From: Niland, Mark
Sent: 14 December 2023 14:54
To: _planningadvice
Subject: FW: South Holland DC Planning

H09-0501-23 - Land off Holbeach Drove Gate, Holbeach Drove

From: Hannah Curtis <hcurtis@lincstrust.co.uk>
Sent: 12 December 2023 15:30
To: Niland, Mark <Mark.Niland@sholland.gov.uk>
Subject: RE: South Holland DC Planning

Solar PV detail

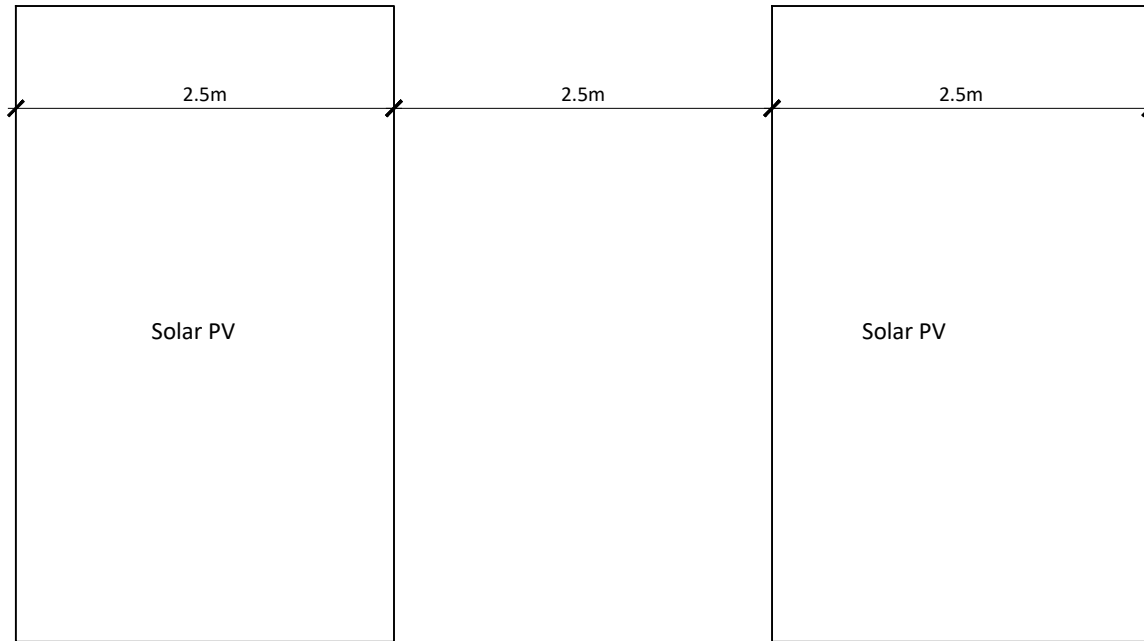
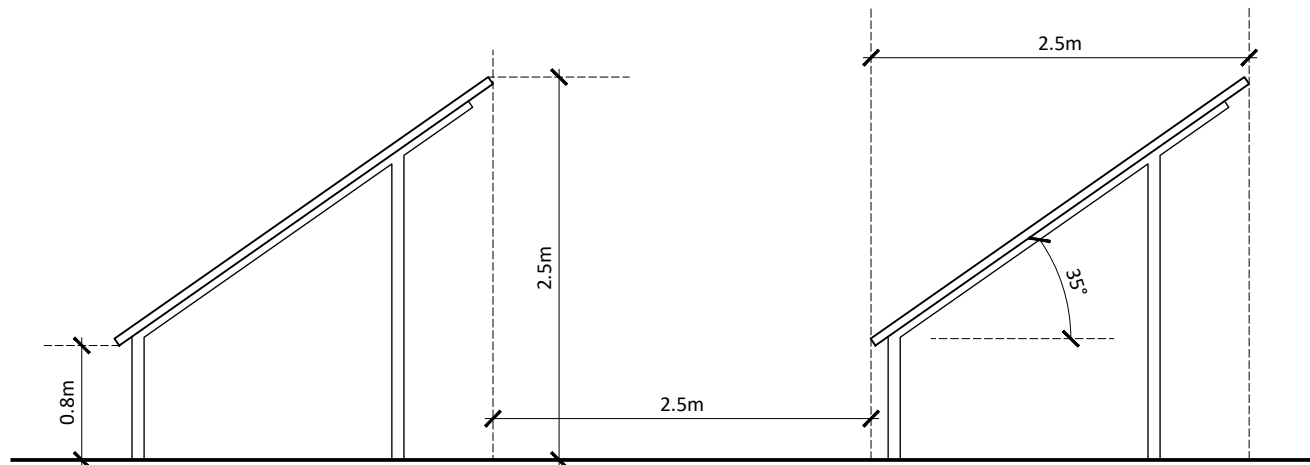
LWTs previous holding objection included the concern that Biodiversity Net Gain has not been incorporated within this project, with no baseline BNG metric calculation, monitoring or management plan found on the planning portal. Ideally, the management plan should include the management of the under-panel area; and mitigation on any impact to Lambert Drain. Have biodiversity improvement, management and monitoring plans been submitted? It was also highlighted that the array arrangement hasn't been included in the plans i.e. the height of and spacing between panels. This will impact the ground flora.
